28.10.2024

Our Ref: SI/01/OVF

Application 3/2024/0766: Old Vicarage Farm Talbot Bridge Road Bashall Eaves BB7 3DB

Proposed barn conversion

Drawing file: planx_downloads / 24_0766_Proposed_Floor_Plans_Elevations_and_Section.pdf

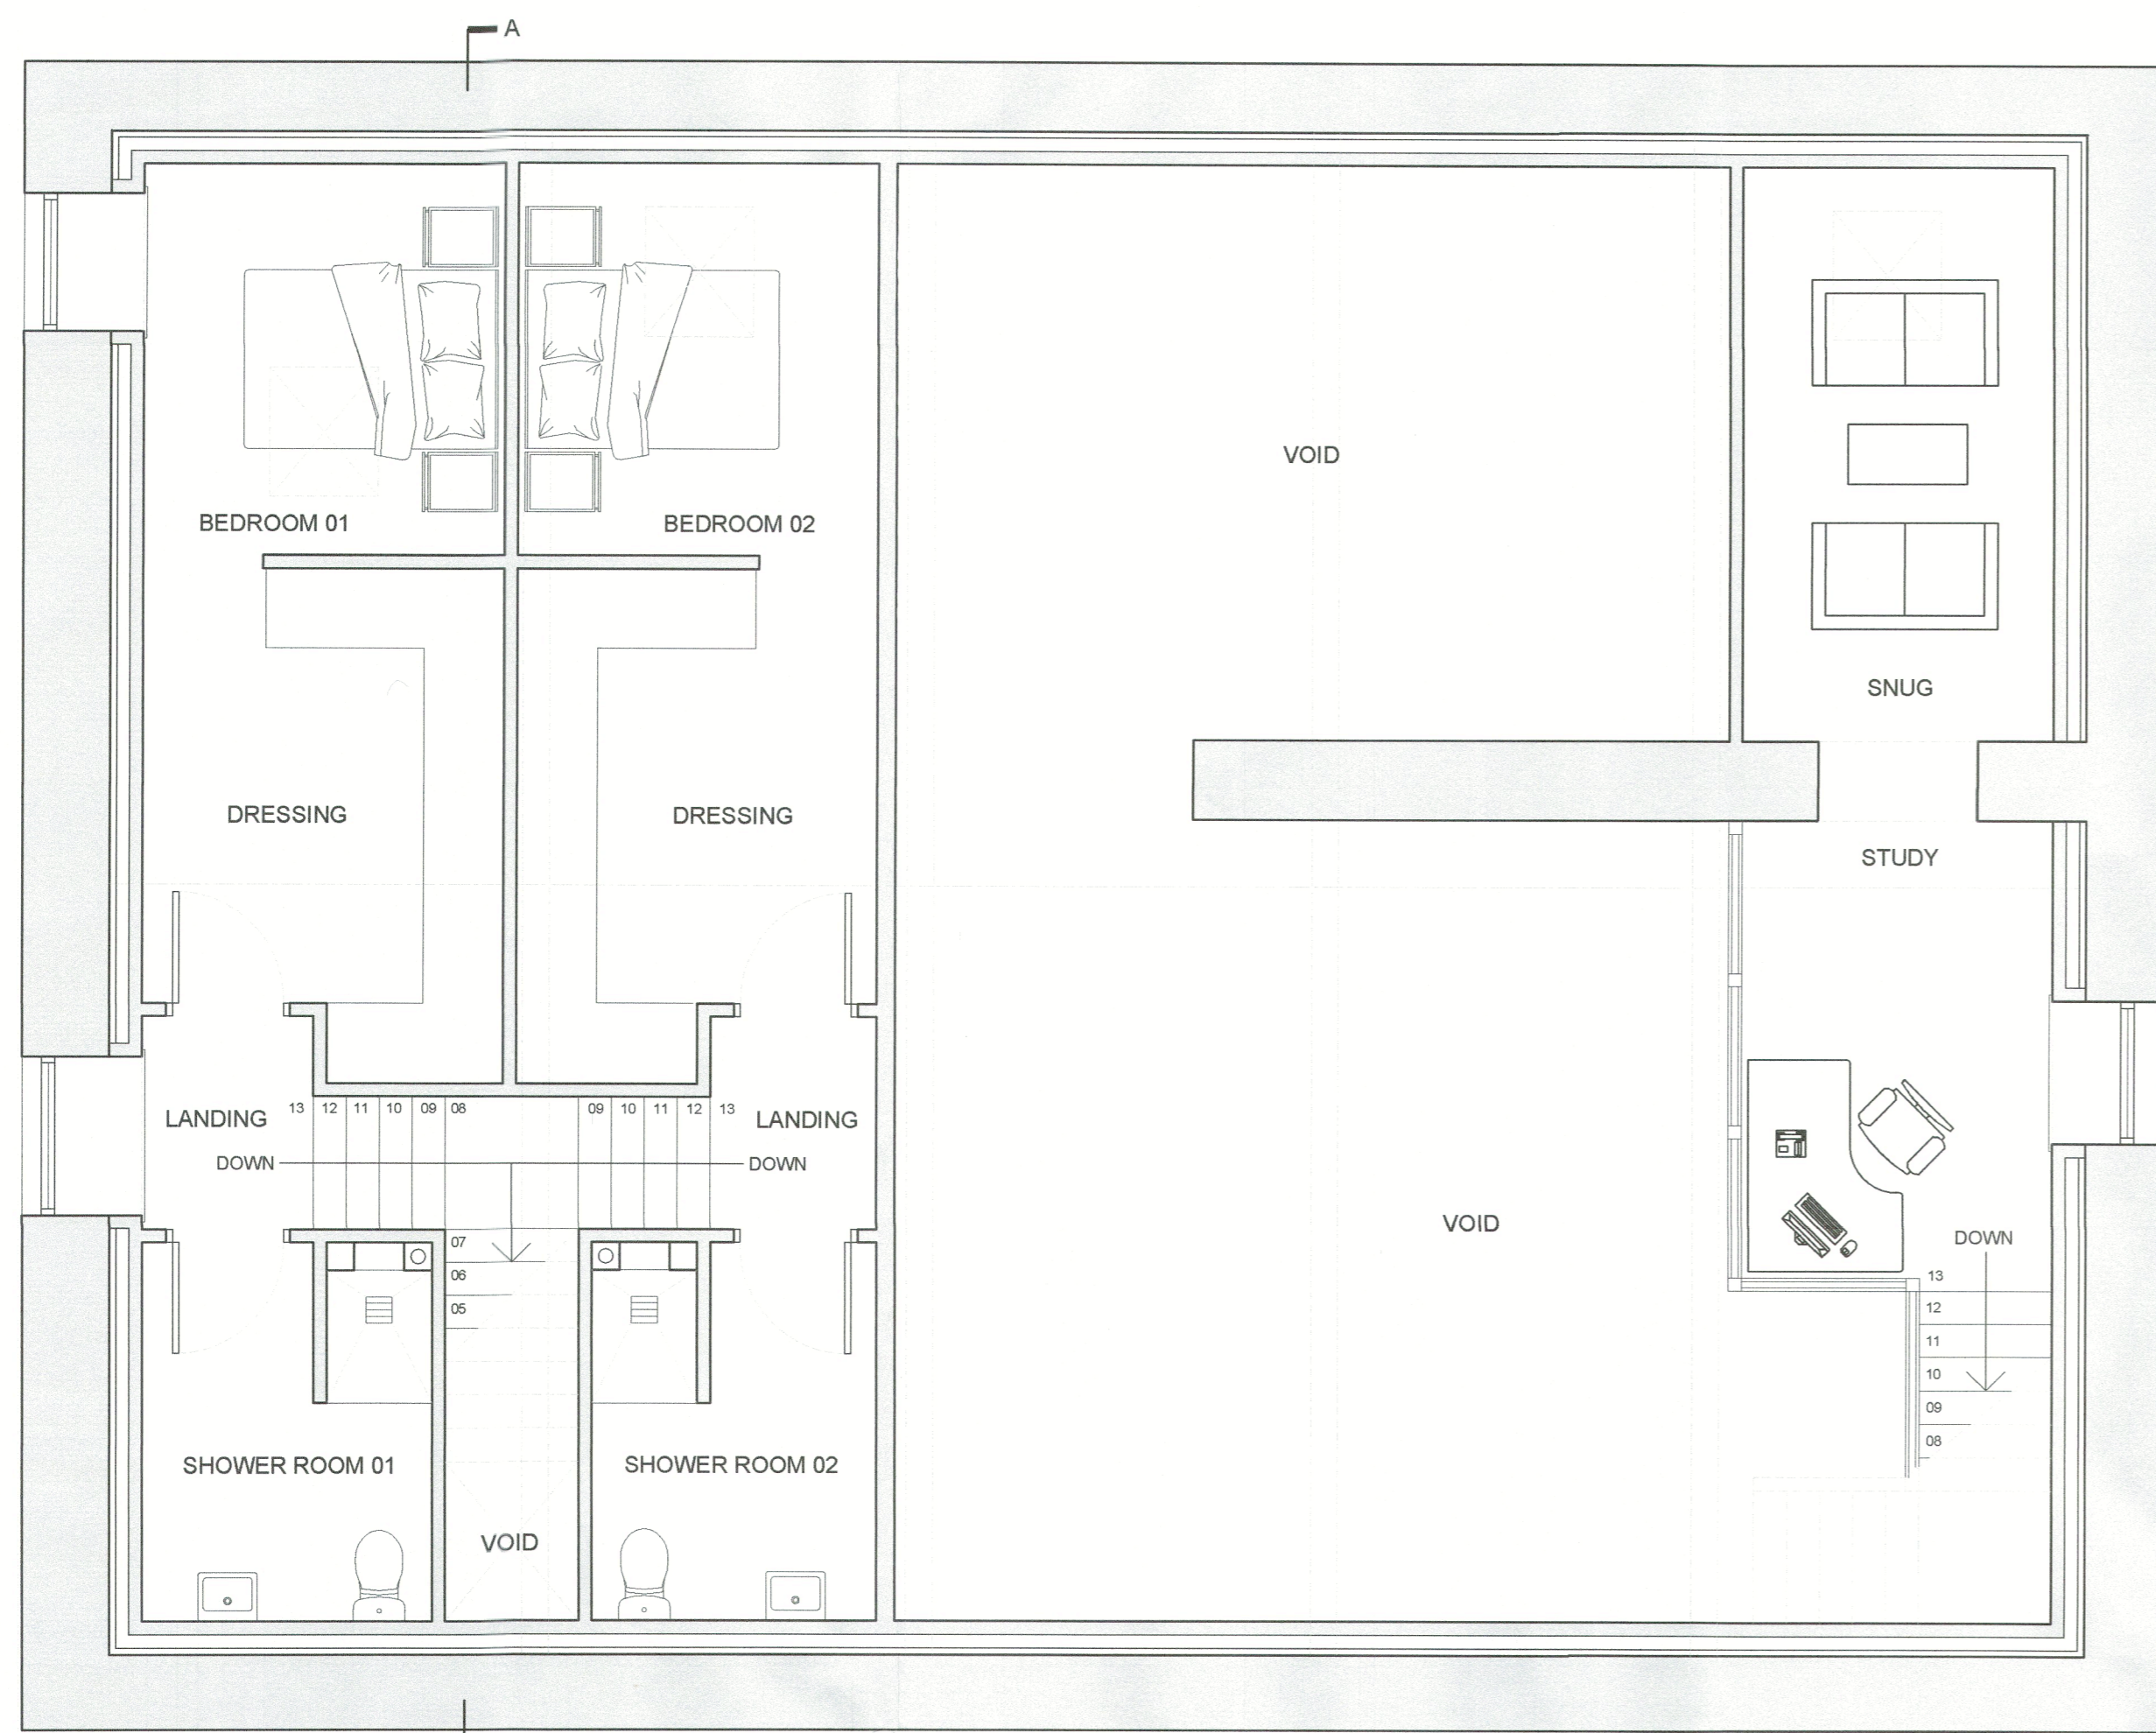
- The mitigation proposed is in the converted building, however from the architects drawings I do not see anywhere that a dedicated void can be allocated to a barn owls as the ceiling is vaulted and velux windows incorporated
